From: Julie Green [REDACTED]
Sent: 07 May 2018 16:22
To: Planning
Cc: Les Green
Subject: Town & County Planning Order 2015 - Notice Under Article 14 of Application for Planning Permission

I am in receipt of your Notice referring to an application for Proposed Covered Parking submitted by applicants Mr & Mrs Kerr and relating to The Granary, Tryne Barn and Sunflowers at Hobbs Court. Although your notice does not mention any planning reference I am presuming you refer to planning reference Y/19/18/L. If this Notice does not relate to this application please let me know which application it relates to.

client	project	drawing	date	drawn	drawing no	revision
Sue & Iain Kerr Lorna & Lee Mason Sasha Osbourne	The Granary, Tryne Barn and Sunflowers, Hobbs Court Bilsham Road, Yapton, BN18 0JY	Garage Block Floor Plans & Elevations	Jan 18	pd	0250 / 100	B
			scale 1:100, 1:10 @ A3	CAD file name:

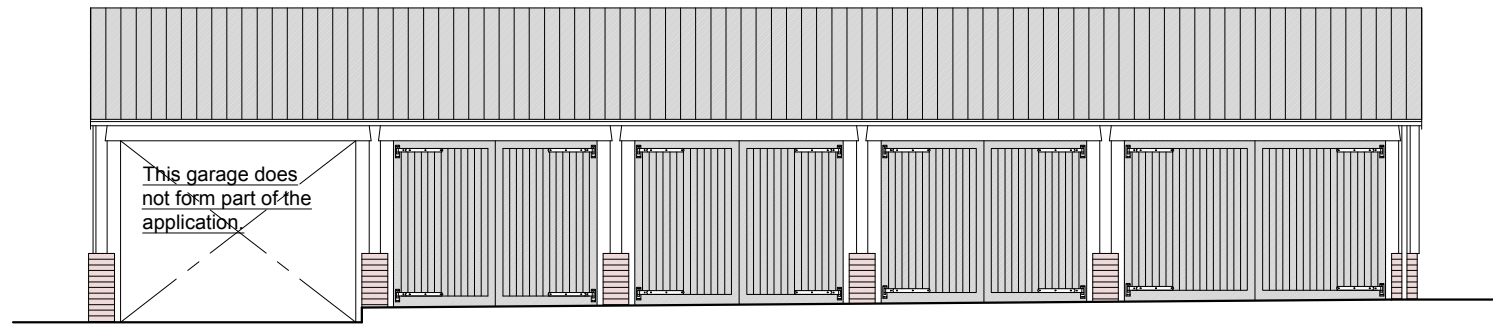
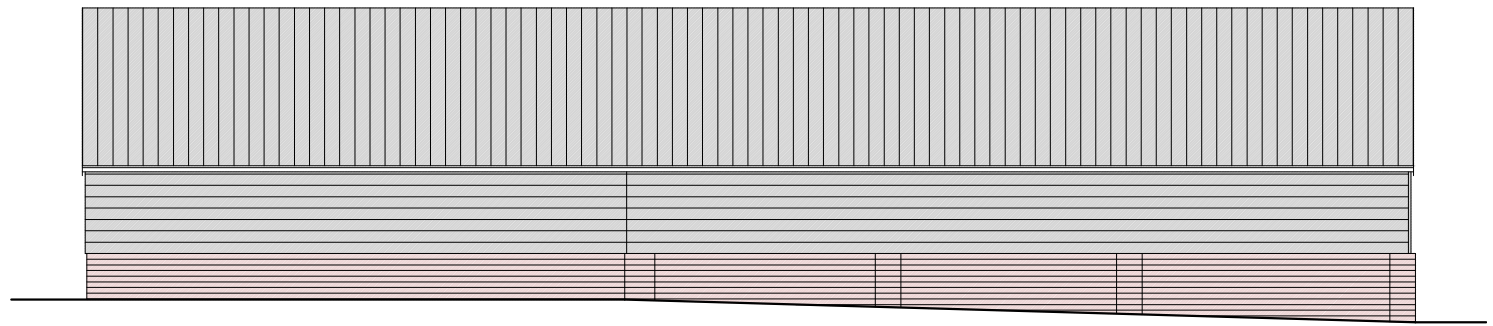
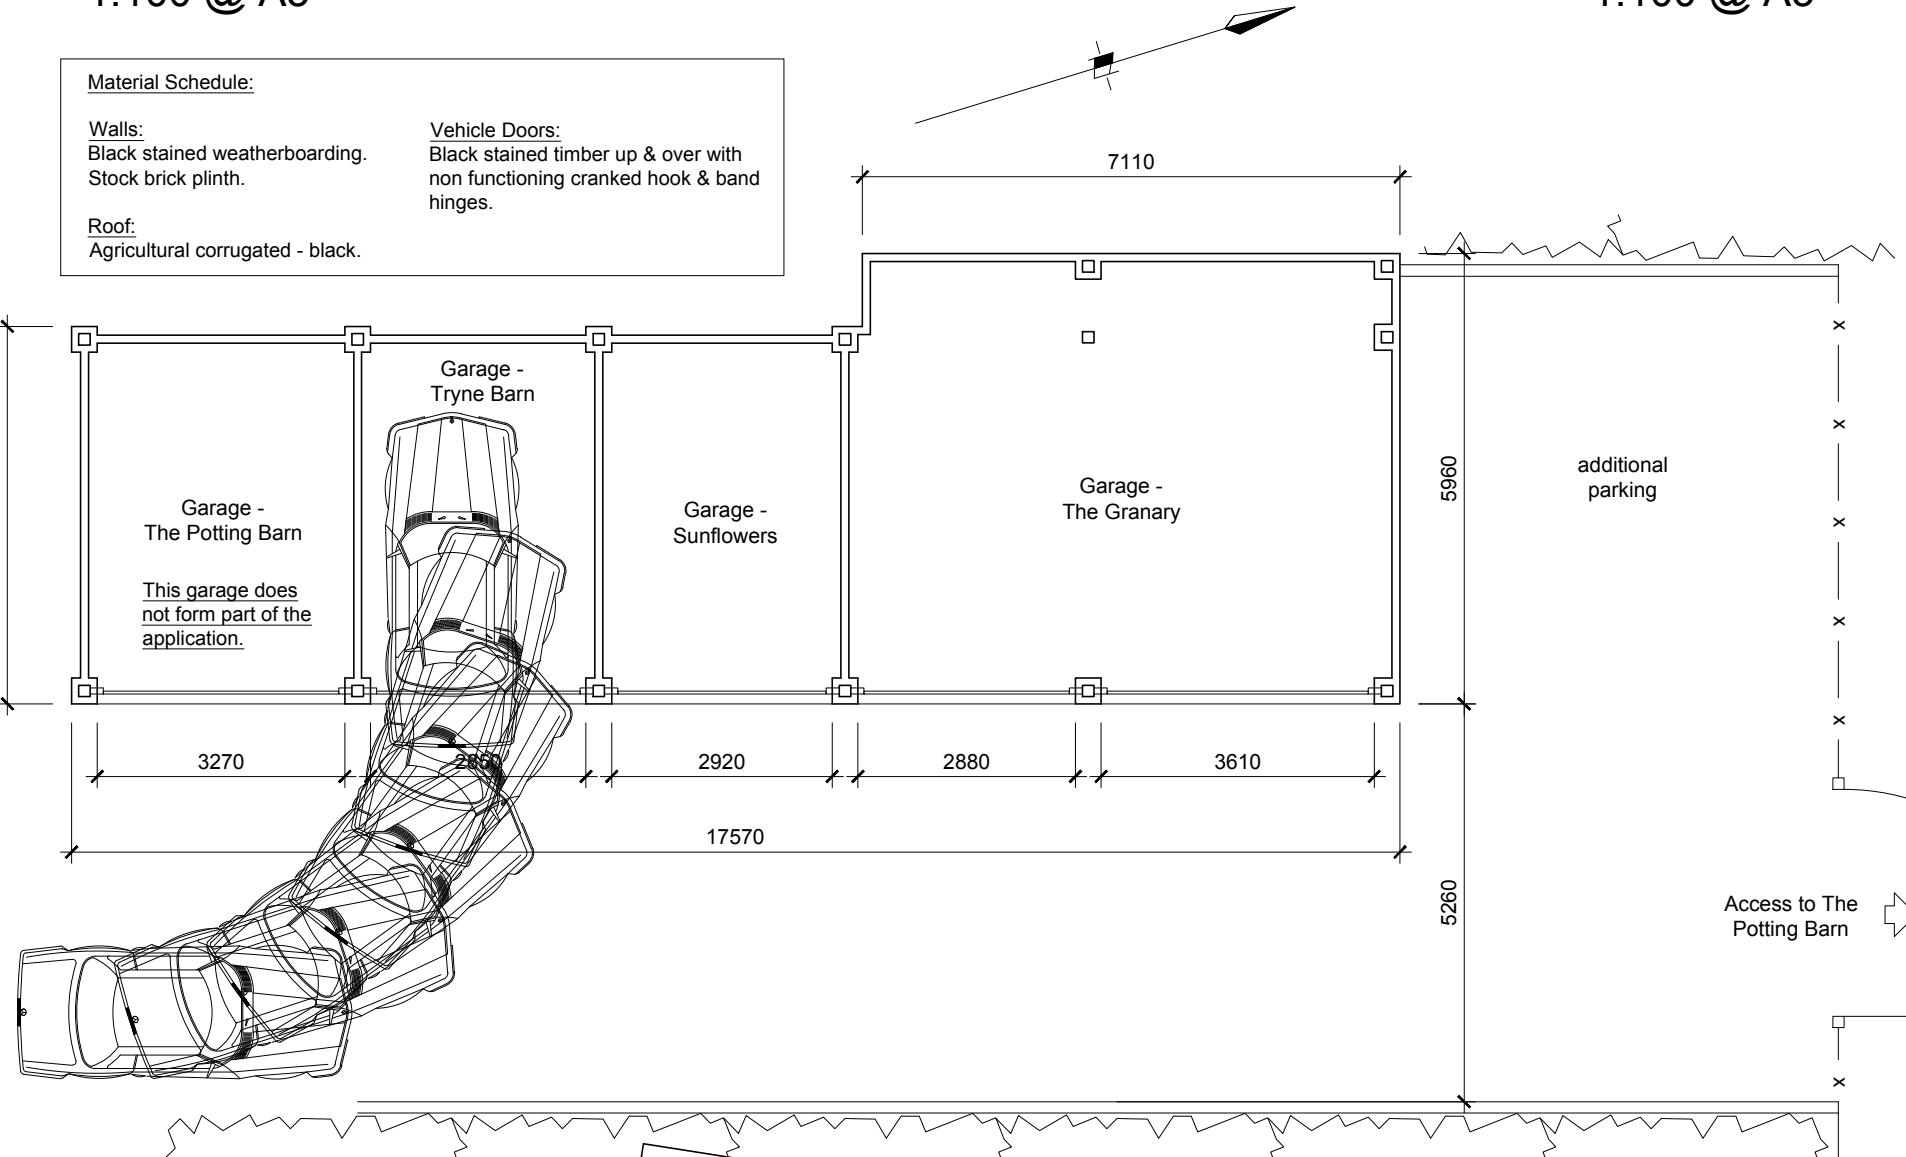
If your Notice does relate to this application Y/19/18/L then my only comment would be that since the three properties mentioned are just three of a of a four property block of five garages/car ports, and since my property looks out on to this garage/car port block, I would prefer that that all five garages have matching doors and that these doors are manufactured of a material meeting the conservation requirements for this Grade 2 listed site, and in keeping with my own property (approved planning application Y/10/15/HH 2015).
